Dear Mr Clark

Application for Approval of Reserved Matters Following Outline Approval

Development Application for Reserved Matters following outline permission LU/47/11 for 46 dwellings - This application may affect the setting of a Listed Building - This is a resubmission of LU/379/18/RES

Location Parcel A2/B6 Hampton Park Toddington Lane Littlehampton

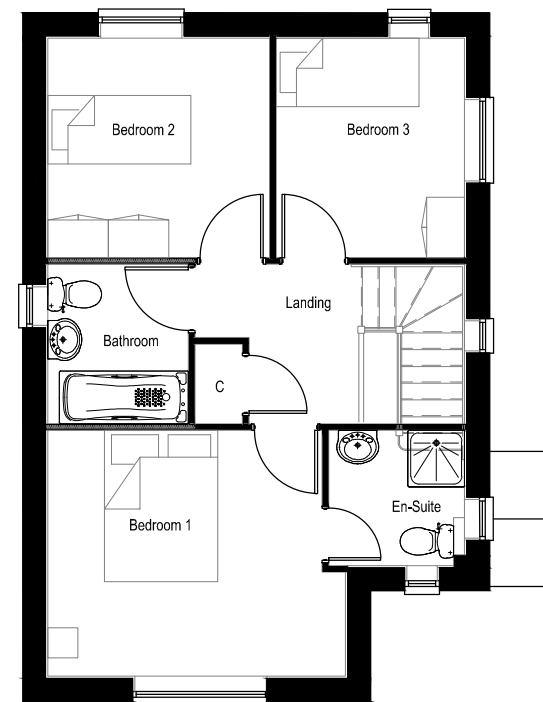
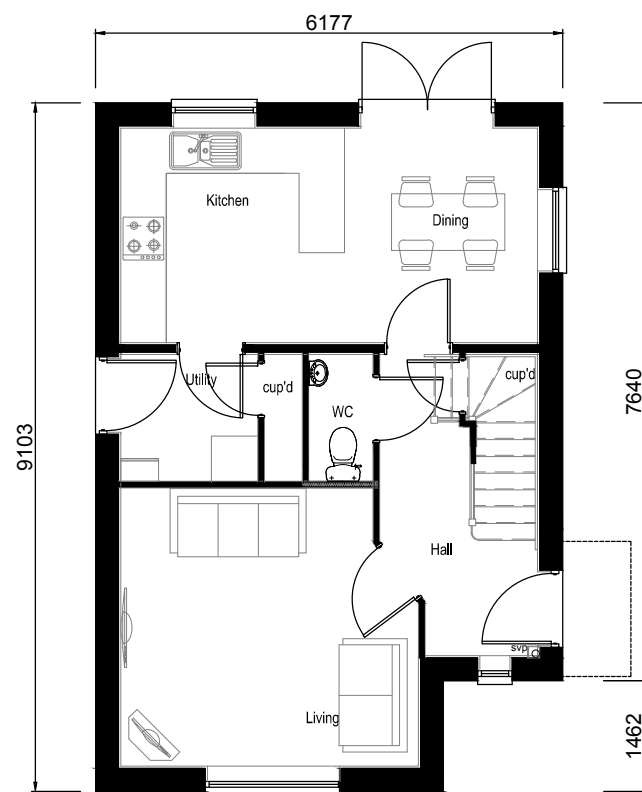
Drawing 544_PL_DER.CR_100 & 200 do not accord. Please forward amended plans accordingly.

PHASE 3 Littlehampton Parcel A2.B6		DATE: March 2018
		SCALE: 1:100 @ A3
		DWG NO: 544_PL_BUK_B_101
Drawing Title: Apartment Block B - Private Proposed First Floor Plan		
Drawing Status: SUBMITTED		Checked: AT ME/RC
		Rev: C

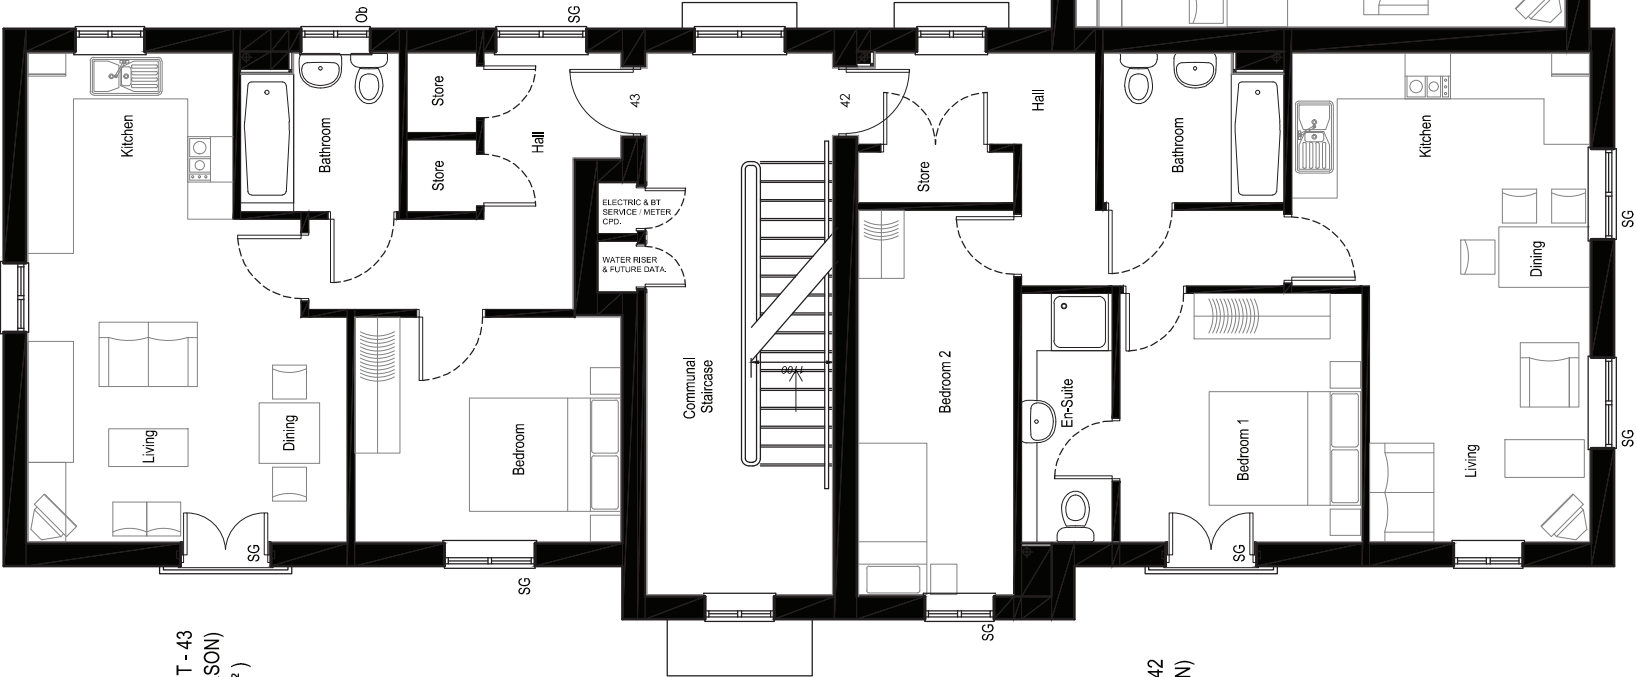
Drawing 544_PL_BLK_B_200 & 101 do not accord. Please forward amended plans accordingly.
